## DEPARTMENT OF PUBLIC WORKS

### MEMORANDUM

**TO:** All Staff  
**FROM:** Public Works Plan Review Team  
**DATE:** January 30, 2023  
**SUBJECT:** SP-22-00007 Davis

**DAVIS SHORT PLAT
PART OF SECTION 31, T. 18 N., R. 20 E., W.M.
WITTAS COUNTY, WASHINGTON**

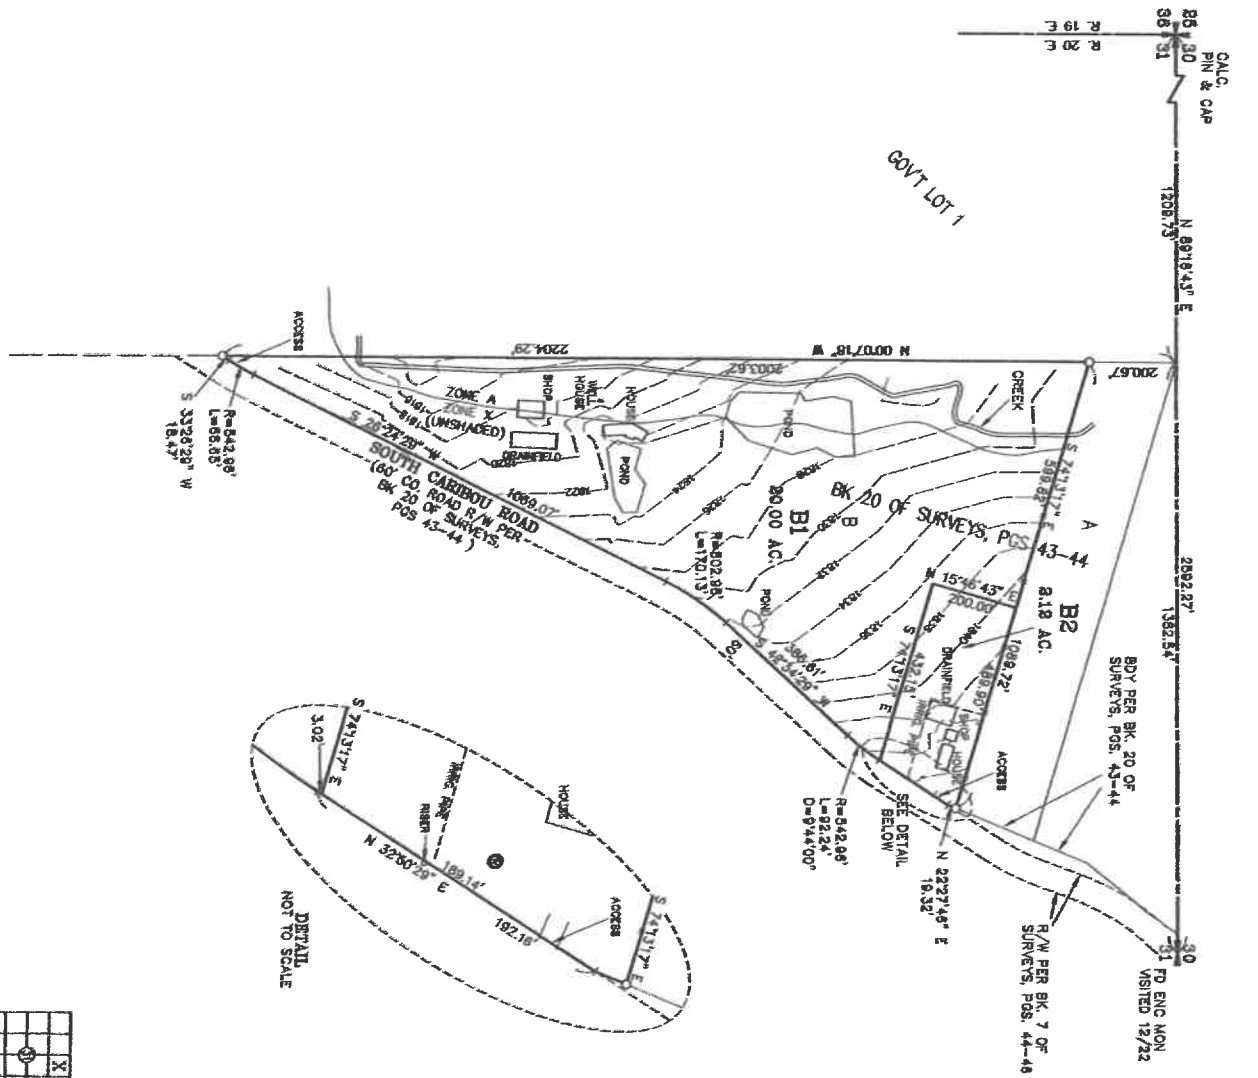
<b>SURVEY</b>	Property corners for the new division shall be shown on the Final short plat. (JT)
<b>FLOOD</b>	<p>A portion of parcel # 715134 is located in the FEMA identified special flood hazard area (100-year floodplain) zone A. If possible, any future development should remain outside of the floodplain in order to reduce risk and avoid mandatory flood insurance purchase requirements. All activities within the floodplain must be permitted through the floodplain development permit process and follow the regulations within KCC 14.08.</p> <p>In accordance with KCC Chapter 14.08.220, All subdivisions as well as new development shall:</p> <ol style="list-style-type: none"> <li>1. Be consistent with the need to minimize flood damage.</li> <li>2. Have public utilities and facilities such as sewer, gas, electrical, and water systems located and constructed to minimize flood damage.</li> <li>3. Have adequate drainage provided to reduce exposure to flood damage.</li> <li>4. Where base flood elevation data has not been provided or is not available from another authoritative source, it shall be generated for subdivision proposals and other proposed developments containing greater than 50 lots or 5 acres (whichever is lesser) and shall be included as part of the application and shall be noted on the final mylar.</li> <li>5. All subdivisions shall show on the face of both the preliminary and final plat, for either short or long plats, the boundary of the 100year floodplain and floodway.</li> </ol> <p>Since the flood zone on the parcel is zone A and base flood elevation (BFE) data is not currently available, <b>KCC 14.08.220(4) is applicable and the BFE data must be provided prior to final plat approval.</b></p> <p>Please contact the Floodplain Administrator at 509-962-7523 for assistance.</p>
